STATEMENT OF DAVID AND PETER ANDERSON AFTER SECOND REMAND

Treehouse Has Not Suffered an “Economic Loss” and the Regulations Are Not “Unduly Oppressive” to Treehouse

SITE PLAN
5637 MERCER WAY
MI TREEHOUSE, LLC
 11030 SE 30TH ST
 BELLEVUE, WA 98004

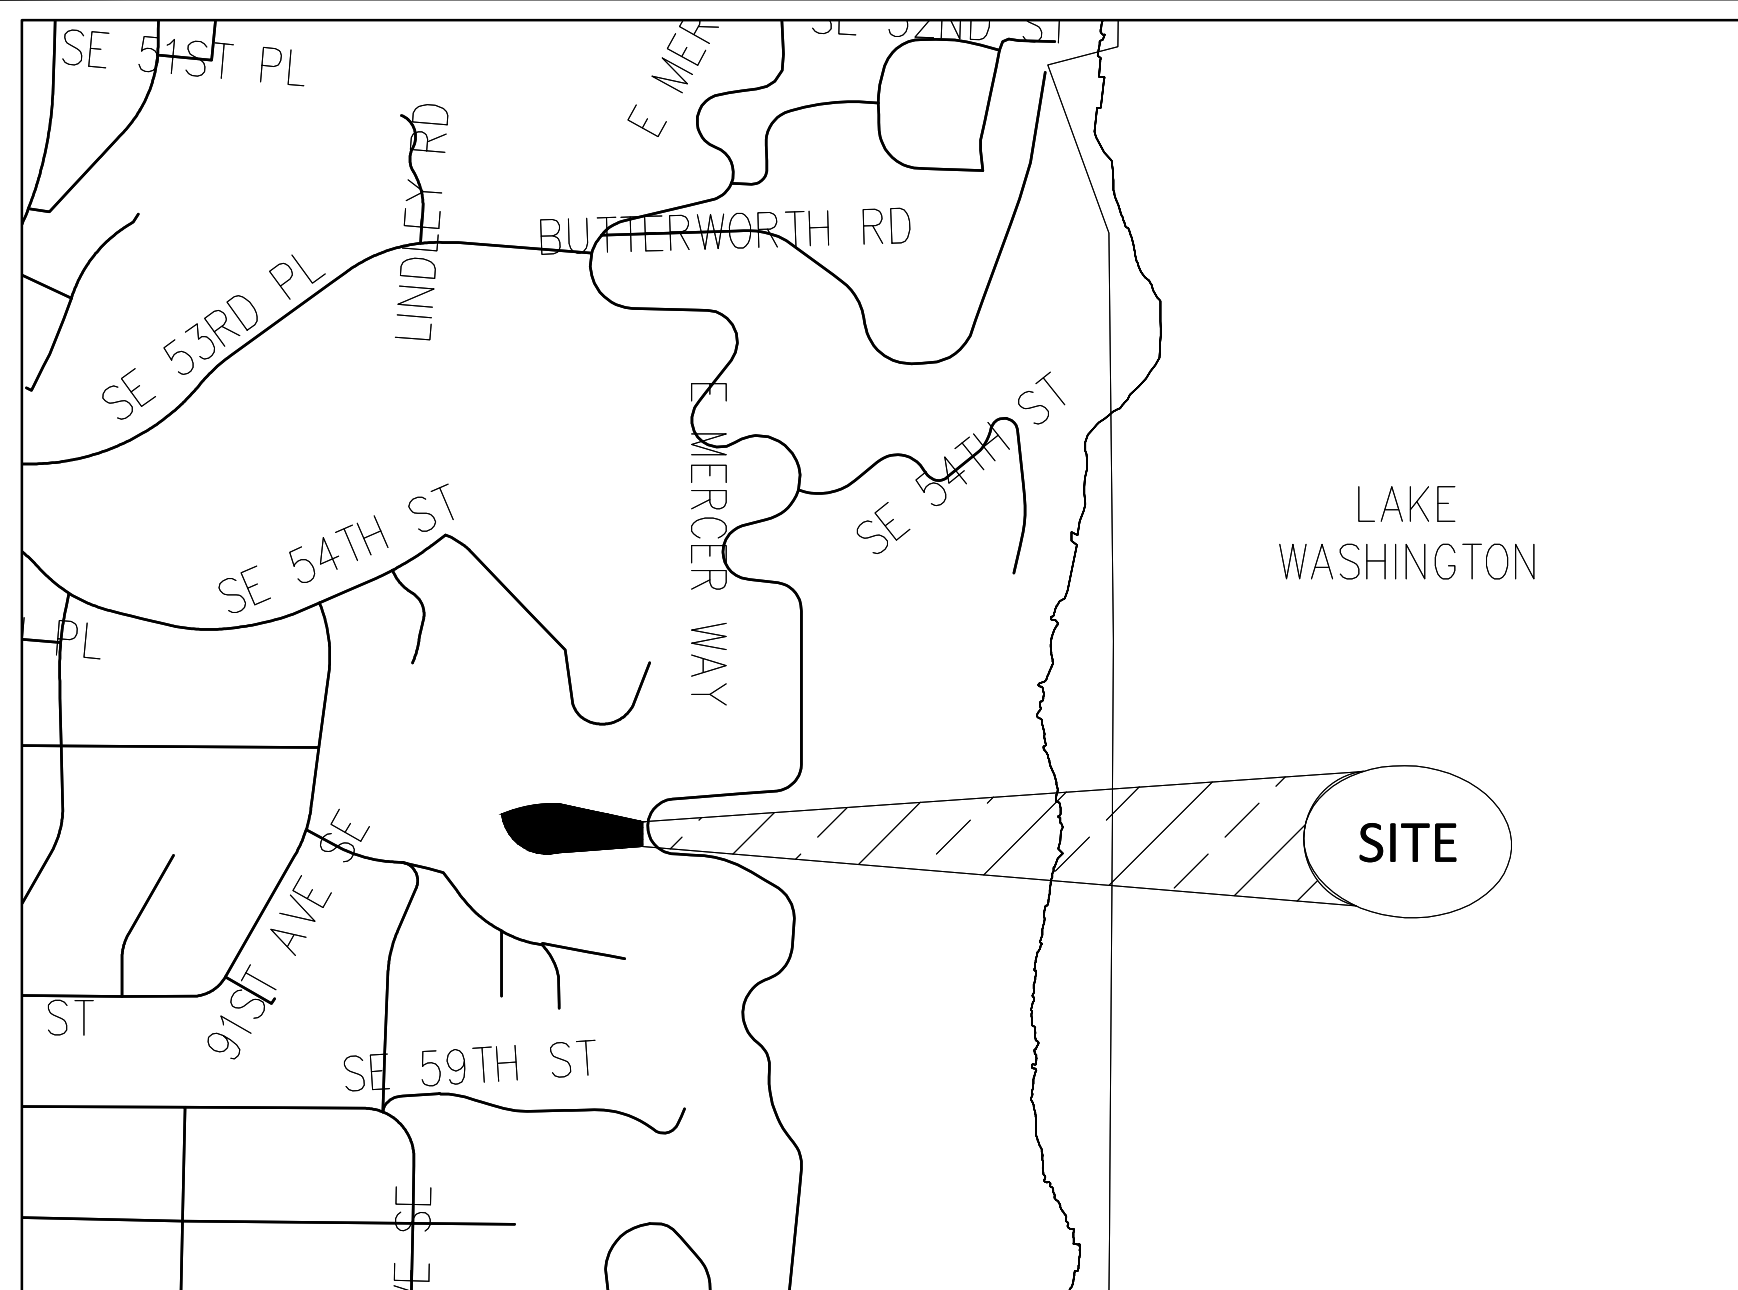
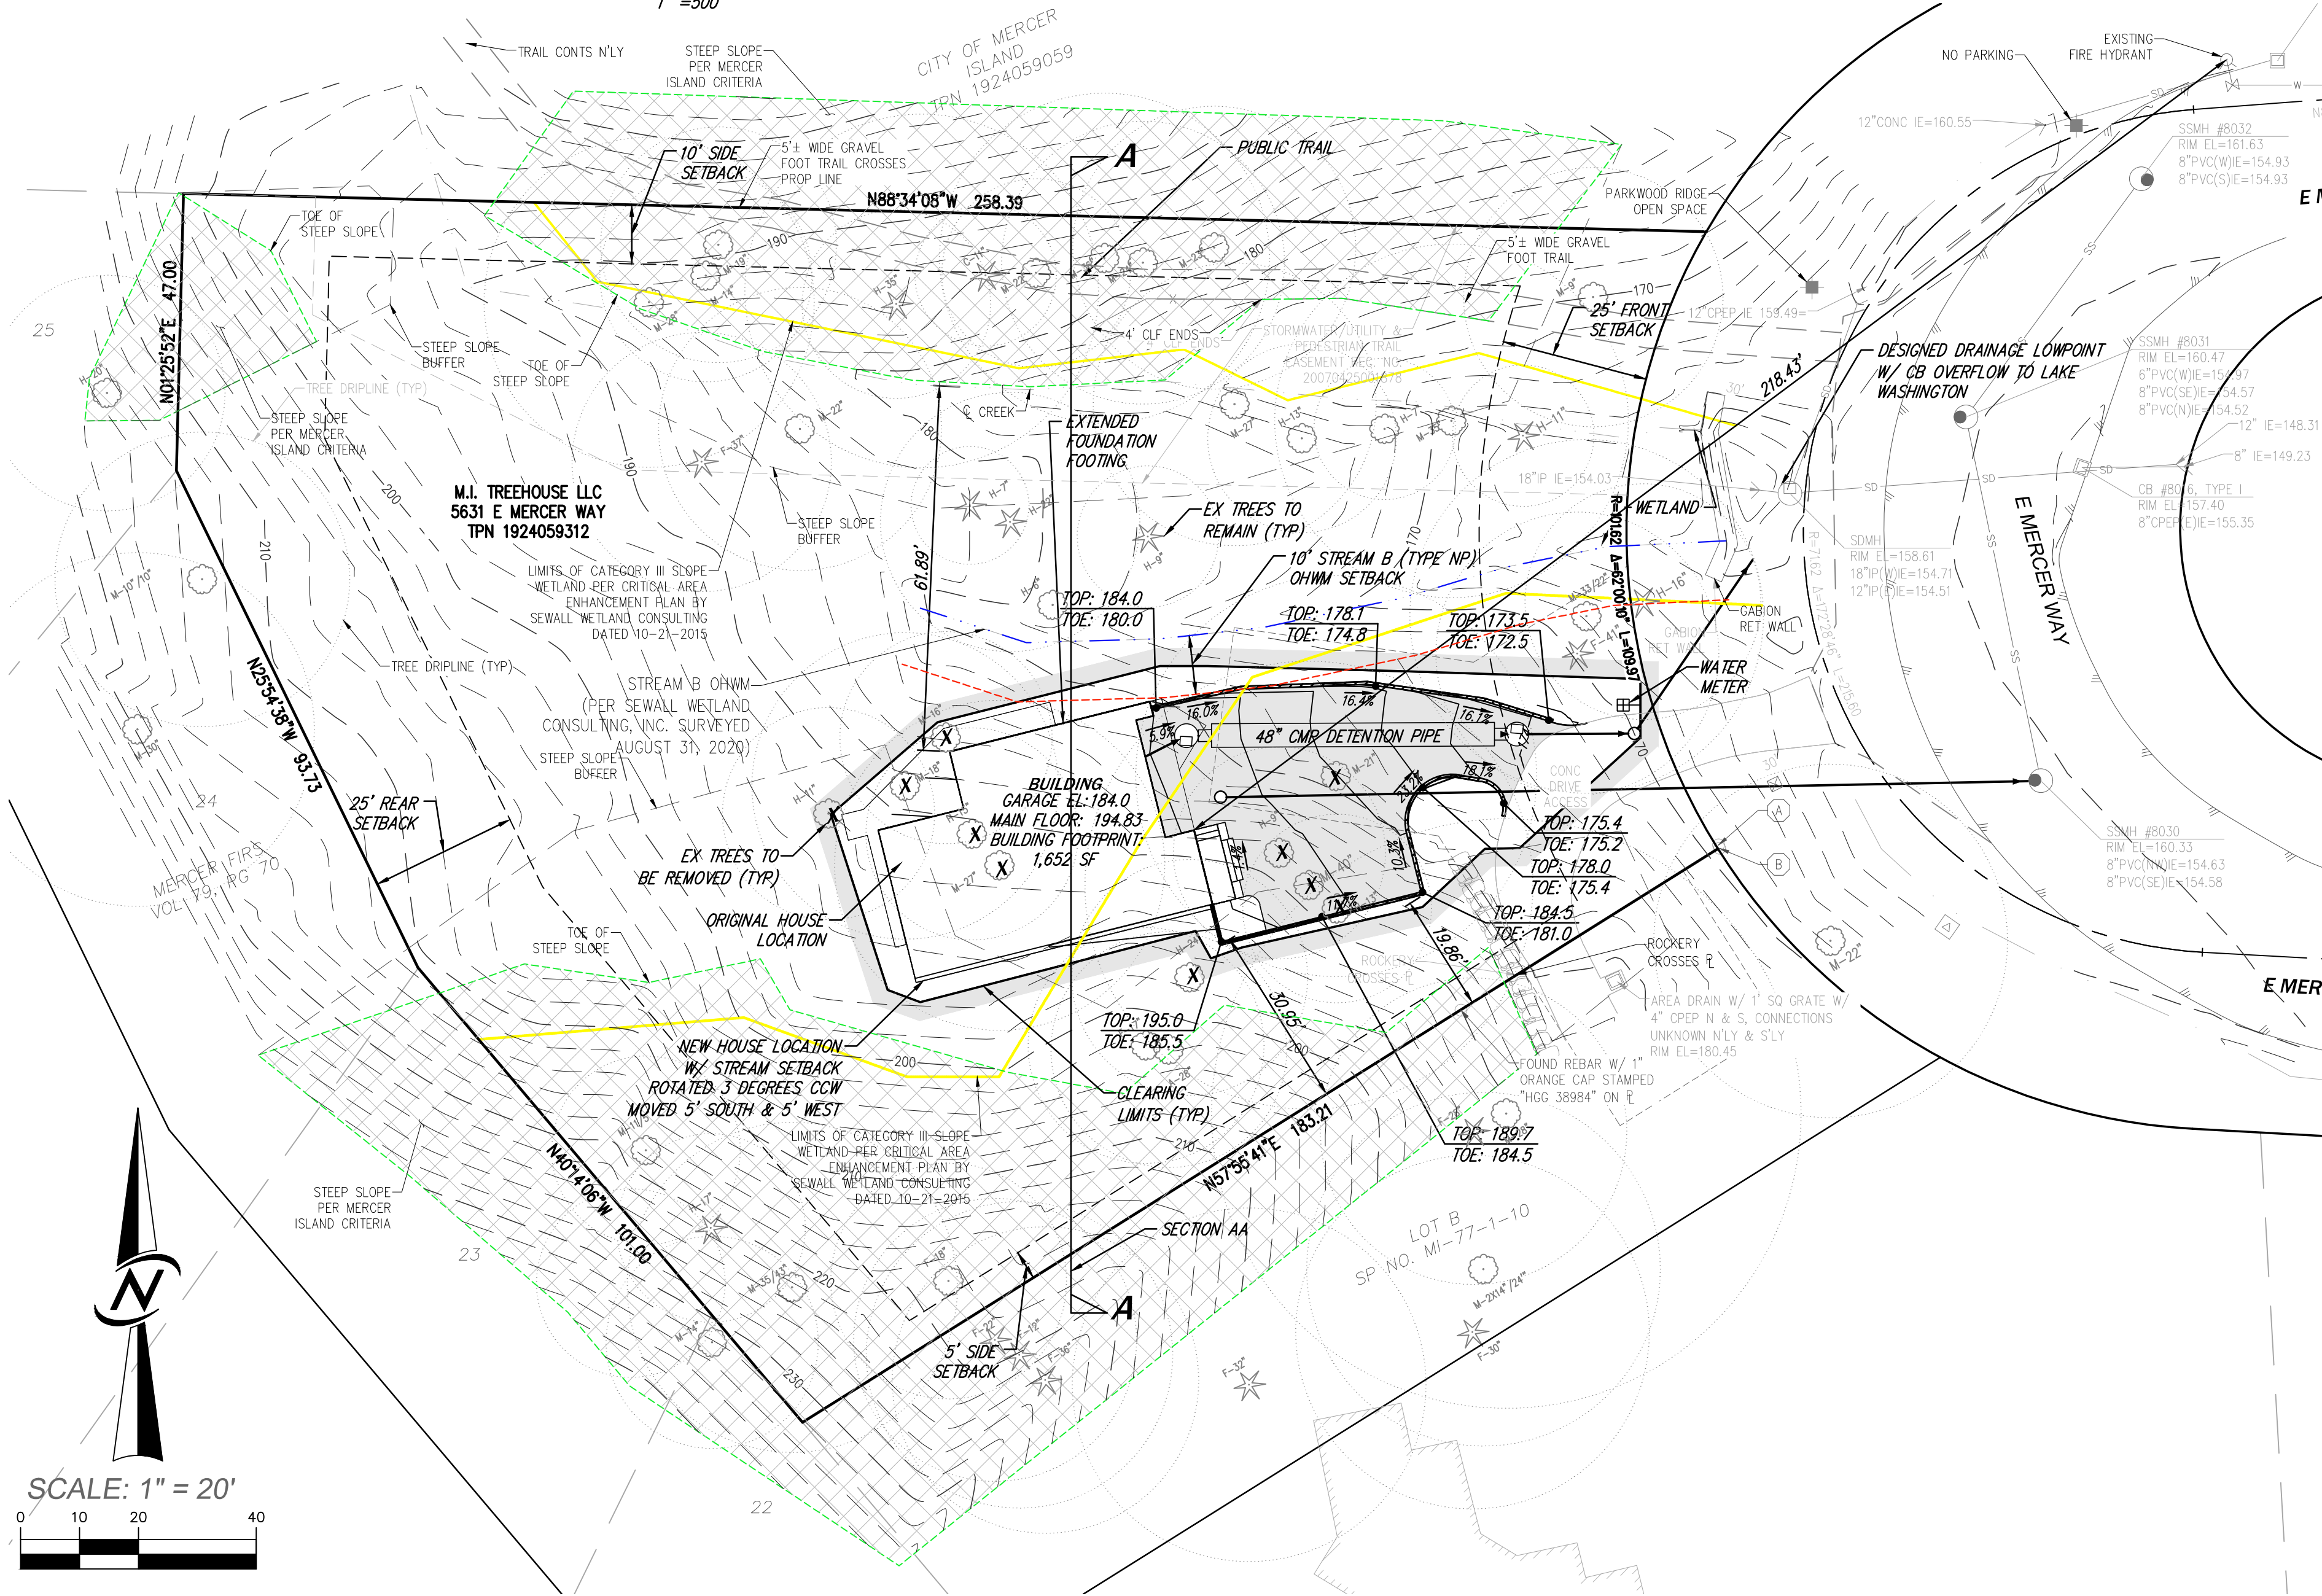
It should also be noted that the report of Geotech Consultants states: “Including the slide catchment wall into the design of the house will provide protection against damage that could result from slide debris reaching the structure.” Exhibit 80g, p. 4. However, as can be seen by Exhibit 87b, the catchment wall faces the slopes below the Stivelman residence and does not face the really steep slopes to the west and southwest. Thus, the catchment wall does not provide protection where protection is most needed.

There are also problems with the Site Plan by Core Design, received August 2, 2021 (Exhibit 87b). For example, the Site Plan shows a building footprint of 1,652 SF, while the more detailed building plans (Exhibit 84) show a building footprint of 1,694 SF. The Site Plan shows

a “48” CMP detention pipe,” while the more detailed building plans show a “5’ CMP detention pipe.” See Exhibit 84. There are also inconsistencies between the Survey (Exhibit 80f) and the Site Plan (Exhibit 87b). One difference that is easily visible is that on the Survey there are numerous trees that are close to, but within, the western boundary of the Treehouse property. On the site plan, these trees are completely absent.
